Application Reference: 2026/0383.

Location: 26 Broadway, Barnsley, S70 6QL.

This application seeks planning permission for the installation of rooflights on the south-western roof slope, the installation of two side dormer windows and the erection of a front porch.

PLANS & ELEVATION

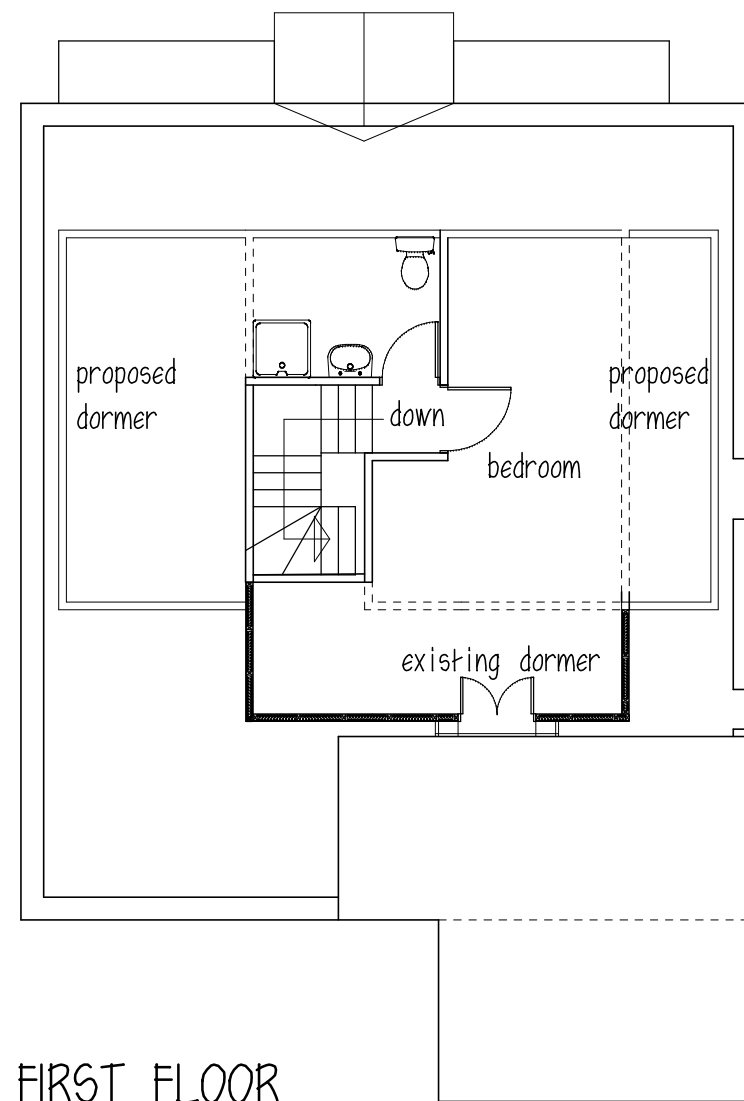
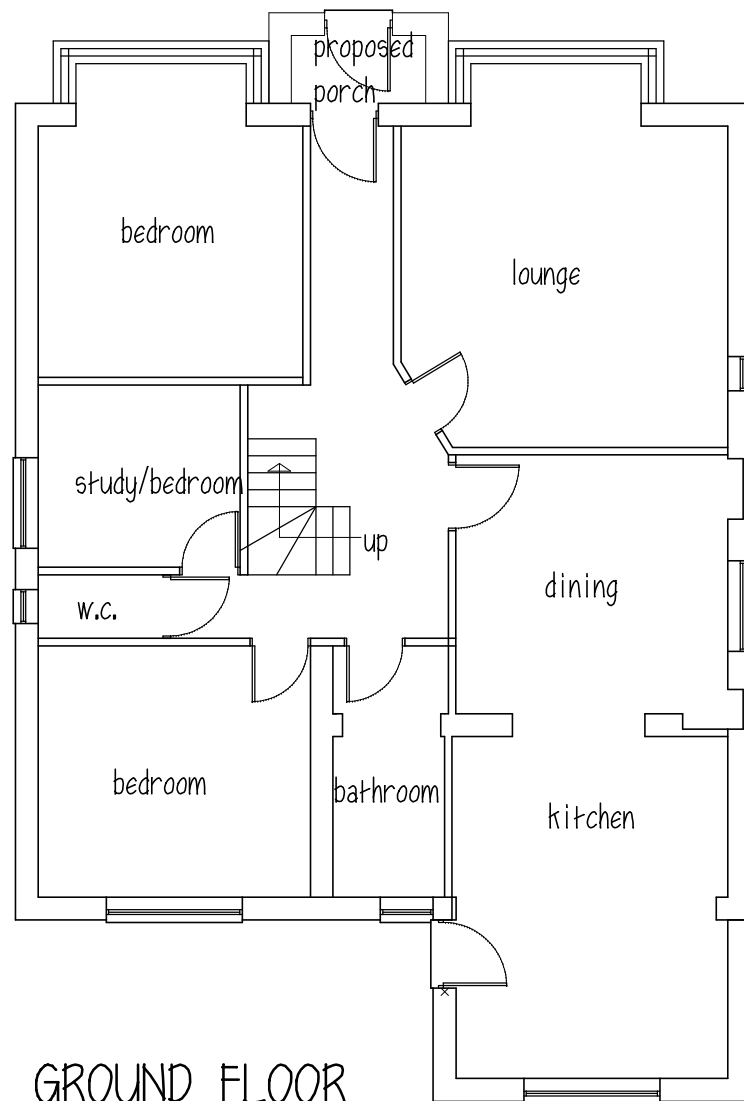
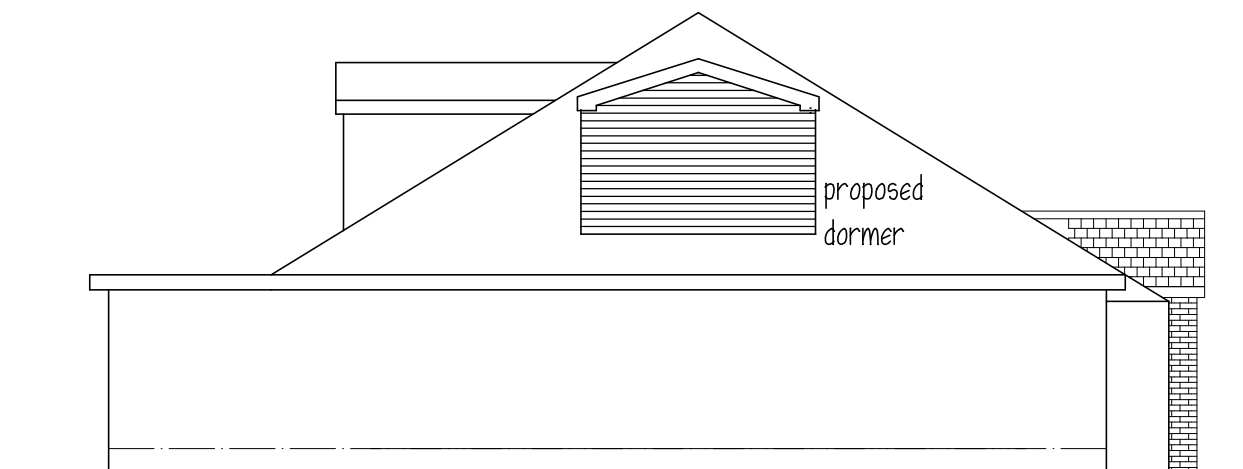
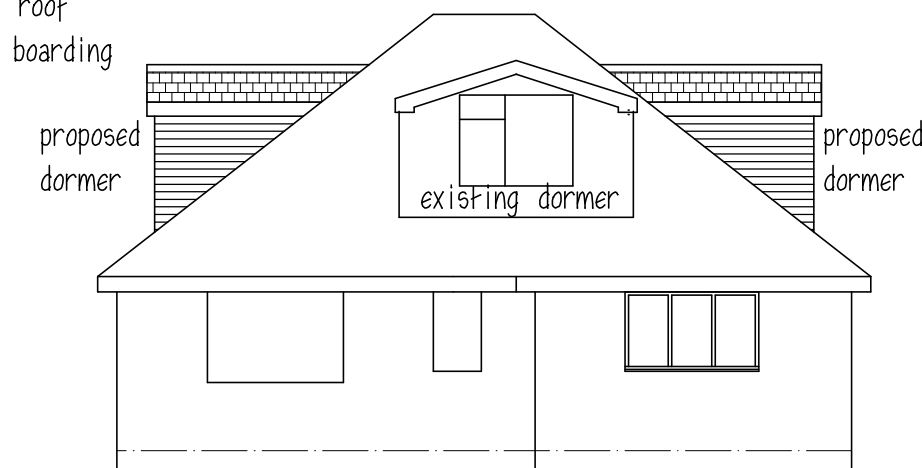
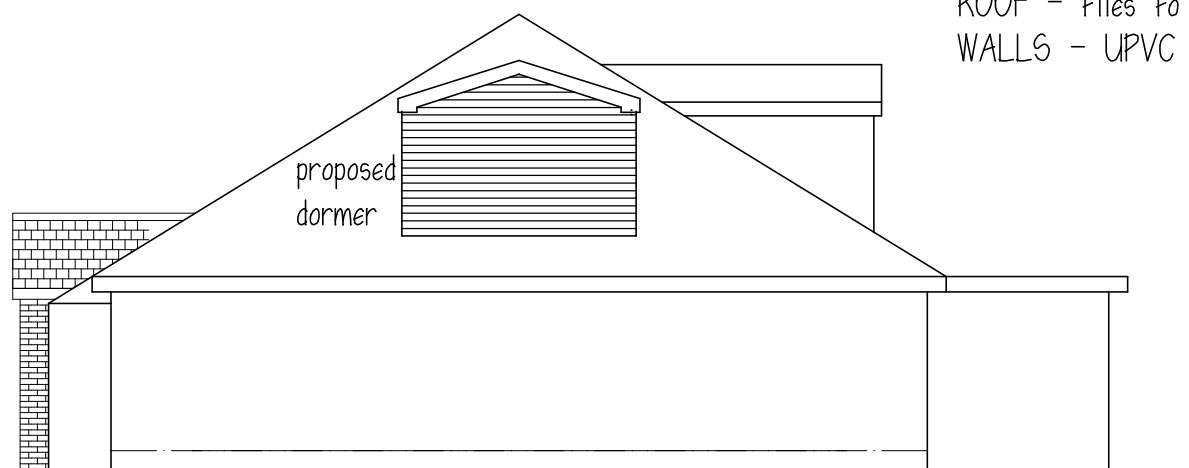
In this instance, the locality is not characterised by dormer windows on frontages, and therefore, this element of the proposal has been removed. The principle of side dormer windows is acceptable and, in this instance, their scale, proportions and positioning have been amended. The proposed dormer windows to the side would be set and positioned centrally within the roof plane and would reflect the scale, proportions and positioning of the existing dormer window to the rear and are greatly improved from the original submitted scheme, which is welcome.

The proposed side dormer windows would appear as subservient elements and would not dominate the roof planes in accordance with the Council's adopted design guidance. The application dwelling-house would maintain the appearance of a modest bungalow with its simple symmetrical character.

The proposed side dormer windows would adopt an amended scale, proportions, and positioning to better reflect an existing dormer window to the rear. The proposed dormer windows would adopt blank elevations and would face the roof or blank side elevations of two adjacent neighbouring properties. The proposed dormer windows would be set central within the existing roof planes of the

Plans and Elevation Rev. B received 29th June 2026.

PLANS & ELEVATION

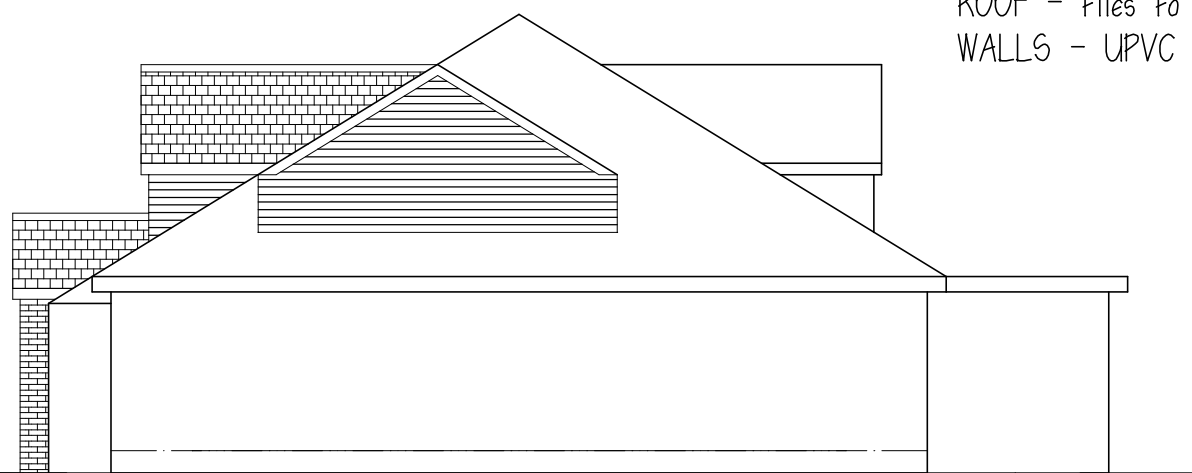
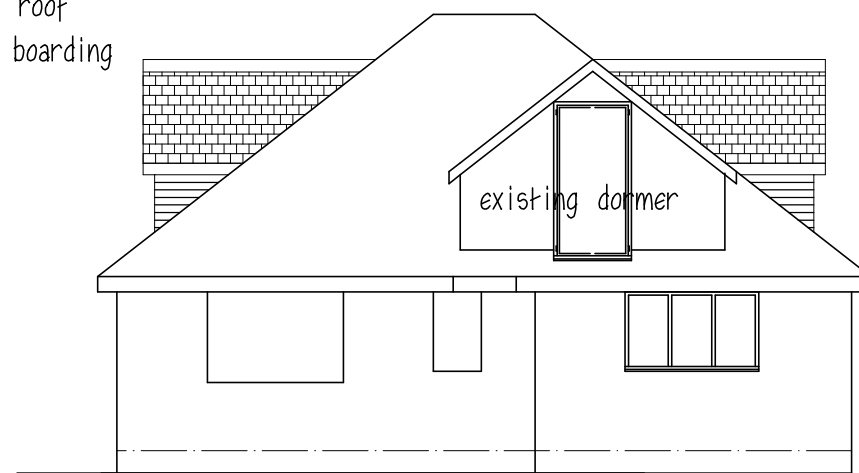
During the application process, this proposal was amended to remove a front dormer window, adjust the scale, proportions and positioning of the proposed side dormer windows. Replacement roof lights to the front were also included.
